**Memorandum**  
**Planning and Urban Development Department**  
**Planning Division**

Date: January 19, 2018

Re: MMC East tower and Visitor Garage Vertical Expansion  
 22 Bramhall Street  
 Maine Medical Center (MMC)

Project #: 2017-289 CBL: 053D007/054H001/064C001

Fig.5.17 Computer-generated shadow study / Existing conditions on June 21, noon

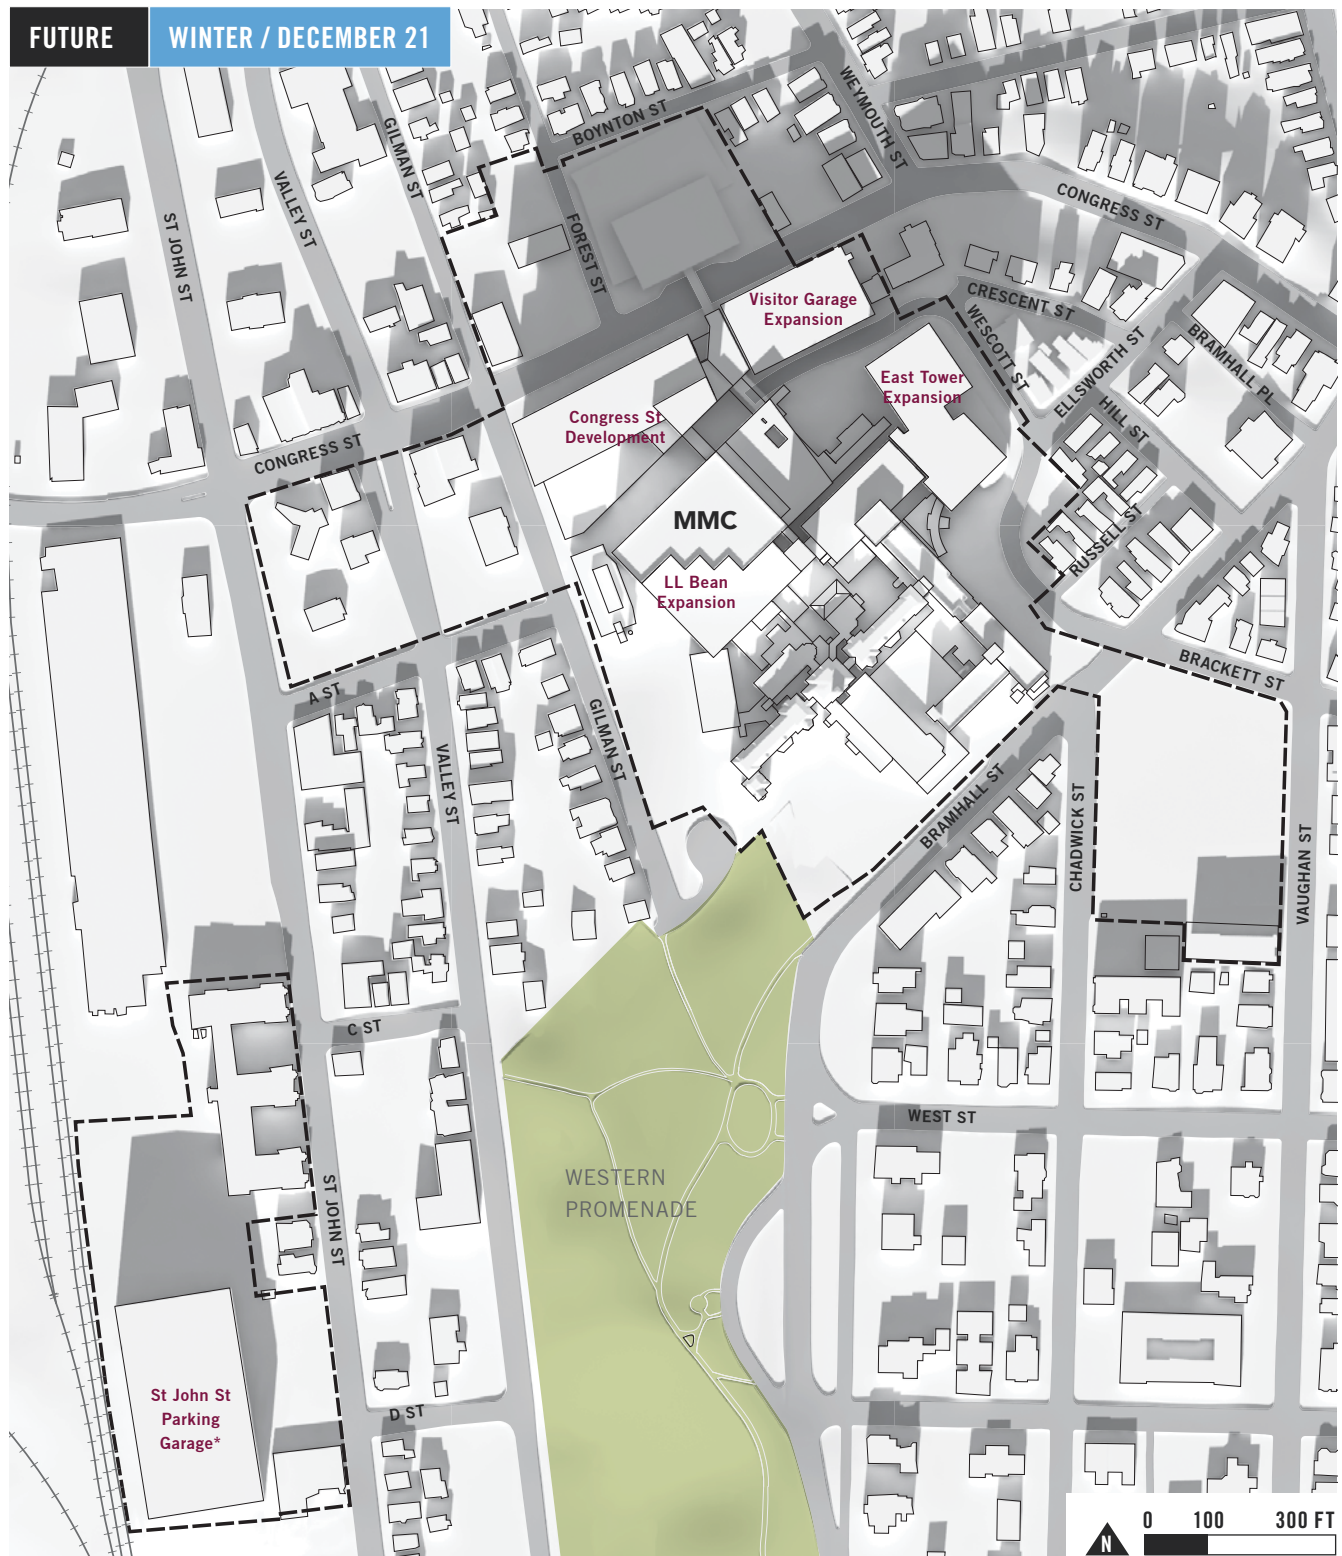
*Minimizing Shadow Impacts* - Shadow impacts were evaluated as part of the IDP process. Both projects increase building height and will inevitably have some shadow impact – the garage height will increase the shadow cast across Congress Street but, as the applicant has argued, shadows on Congress Street are unavoidable due to the terrain, orientation, and street position. Refer to Plan 13 for shadow analysis of the approved IDP building heights – a couple of residential buildings are impacted in the winter by the increased height.

**A20-20**

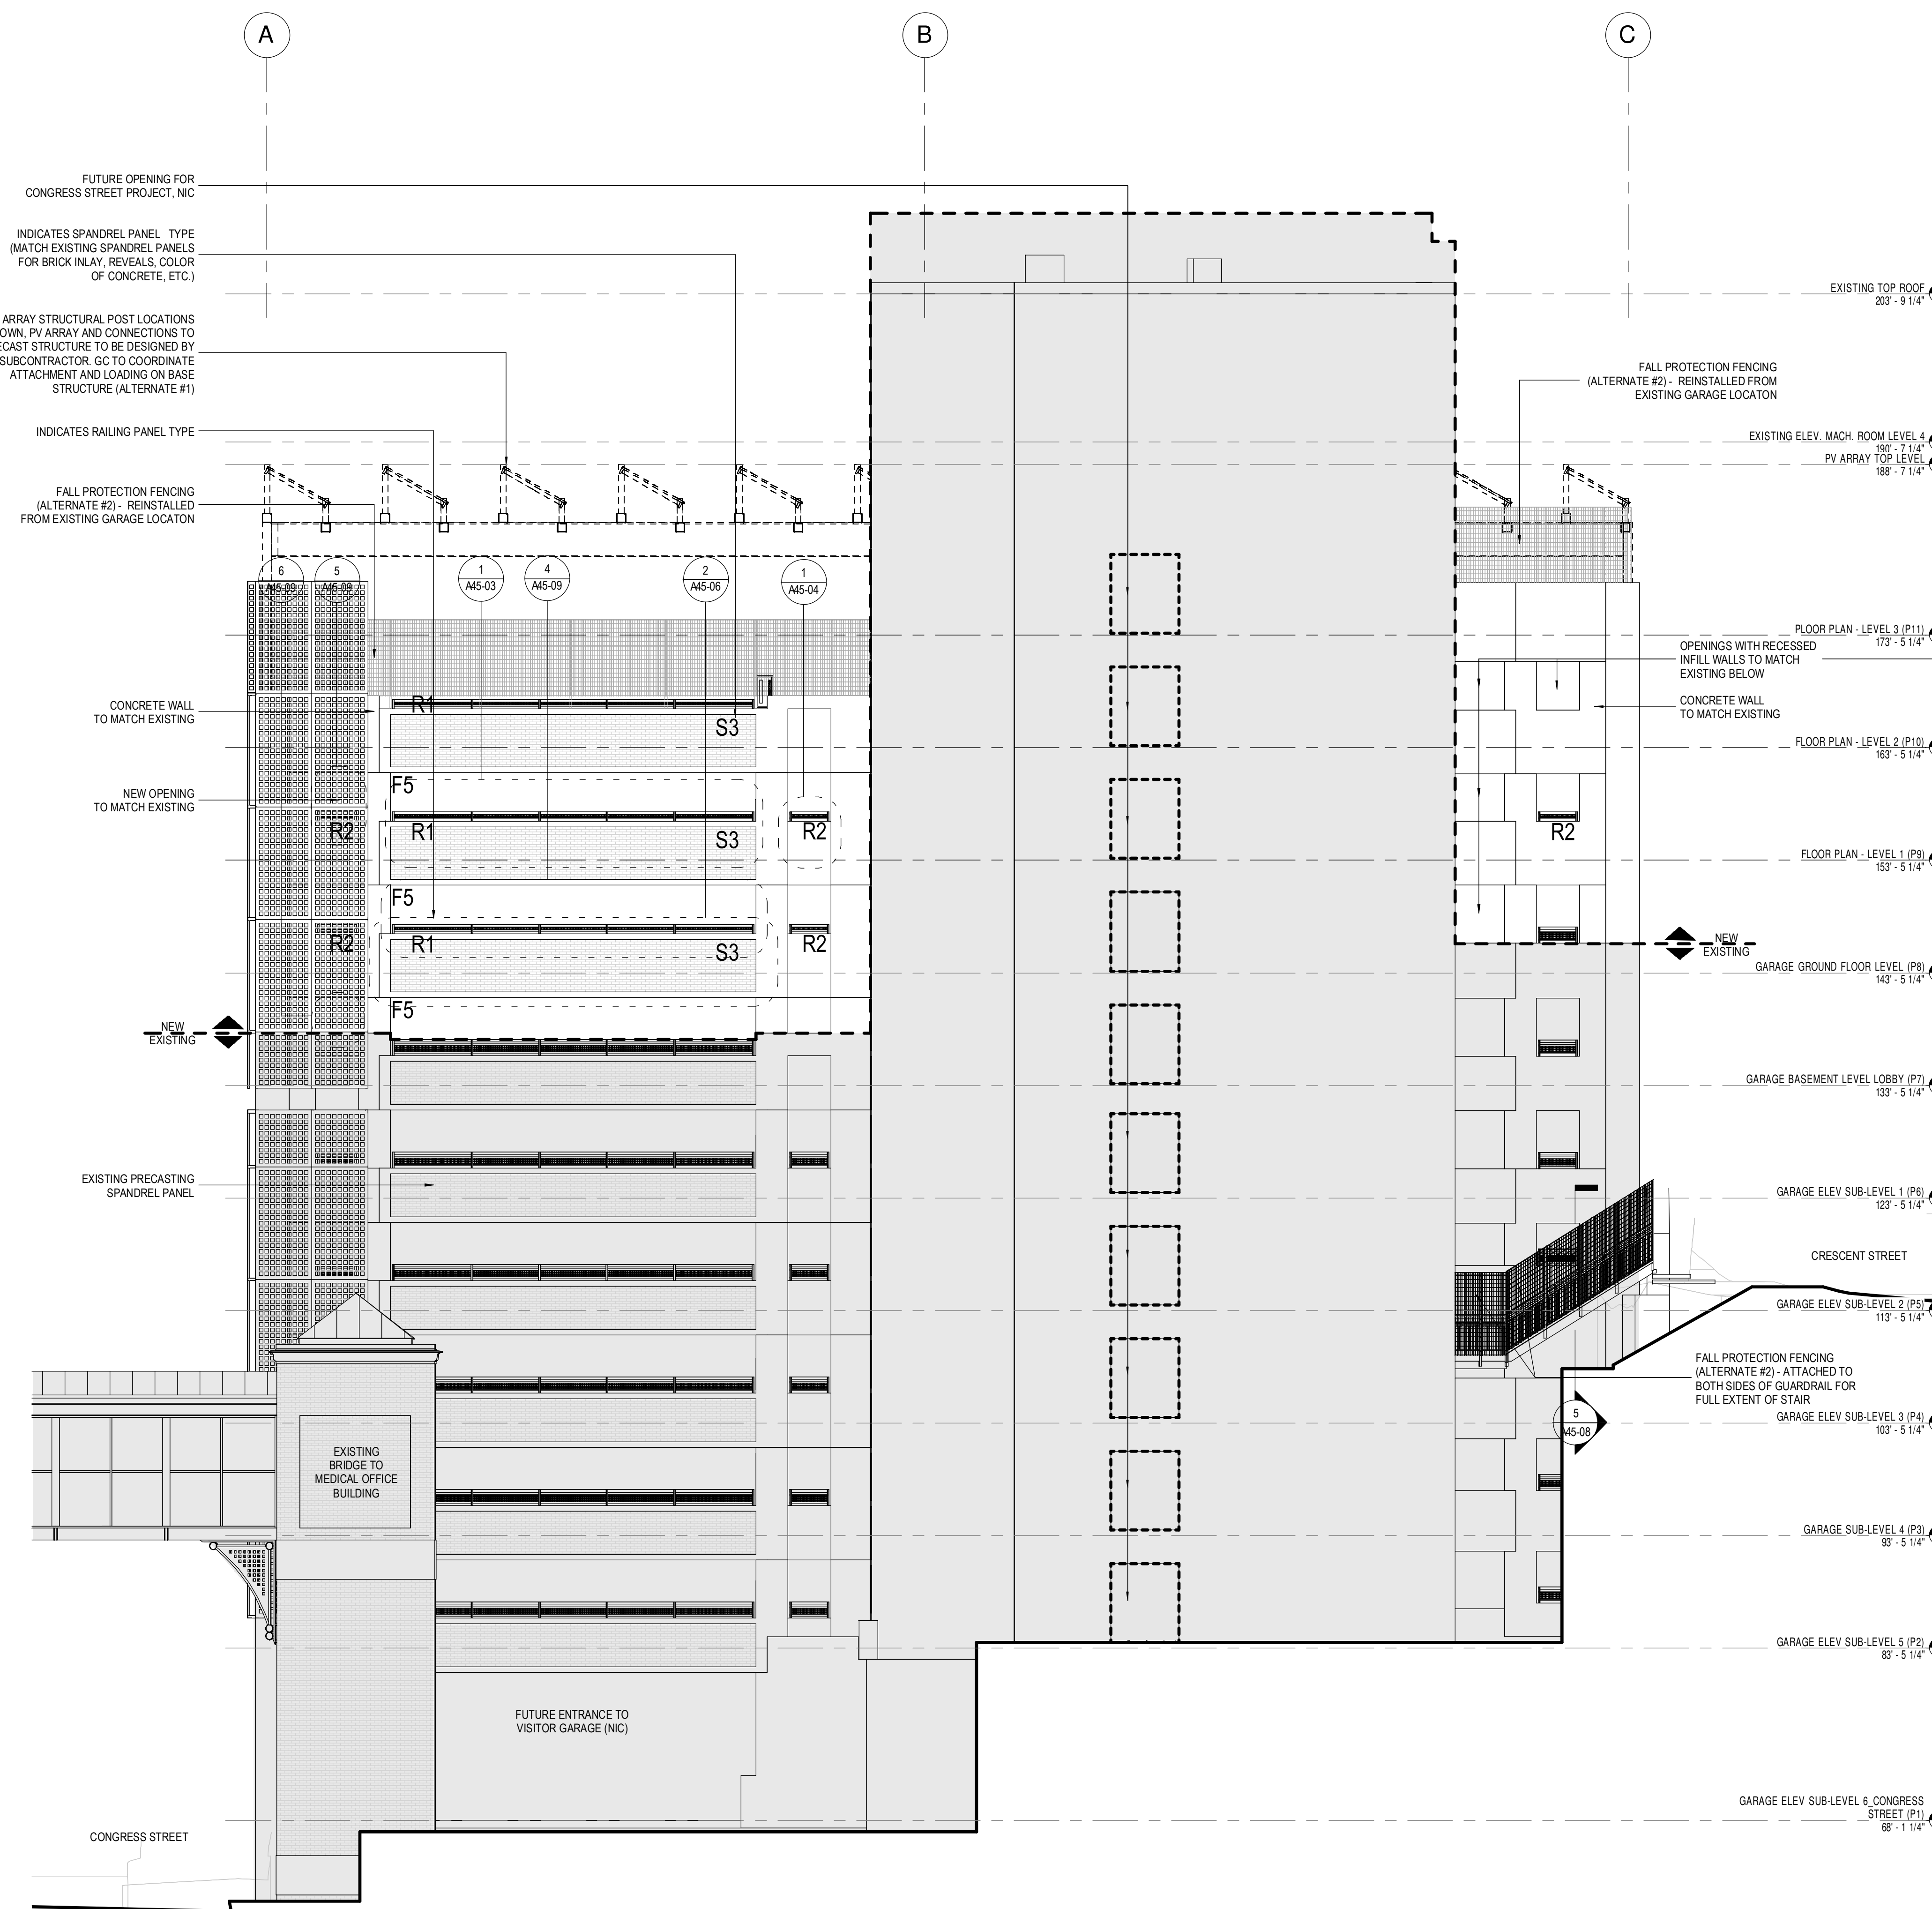
- Please provide a **rendering** showing the visitor garage project in context on Congress Street.
- **More information** is requested regarding materials – label materials on elevations.
- **More information** is requested regarding site lighting.

Visitor Garage: The massing, roof forms, rhythms, and material relationships remain mostly unchanged from the existing conditions. **Scale is the most significant change to this building – staff have requested street view renderings to understand how that scale change will be experienced on the street.**

Visitor Garage: The proposal maintains the existing material palette of brick, concrete, and metal screen. Staff agree this is a logical selection to provide consistency to the building. **However, staff are concerned about the loss of the canopy on the stair tower as an architectural feature.**

Visitor Garage: **Rooftop appurtenances have not been adequately screened or integrated into the building design - this is especially of concern for the long views.**

Visitor Garage: Screening methods will follow the established existing design – solid wall with metal mesh railing with a trellis accent – this current condition successfully screens cars/headlights from Congress and Crescent streets. The current design includes a curtain wall stair tower with an accentuated canopy feature – **this roof element appears to be removed from the new addition and rooftop mechanicals are shown without screening or design integration. Staff suggest keeping an element like the canopy will help screen the rooftop mechanicals and meet the guideline of providing architectural interest on upper floors – especially considering with the increased height, these elements will become even more visible from long views.** For street activation, see comments 7. above.
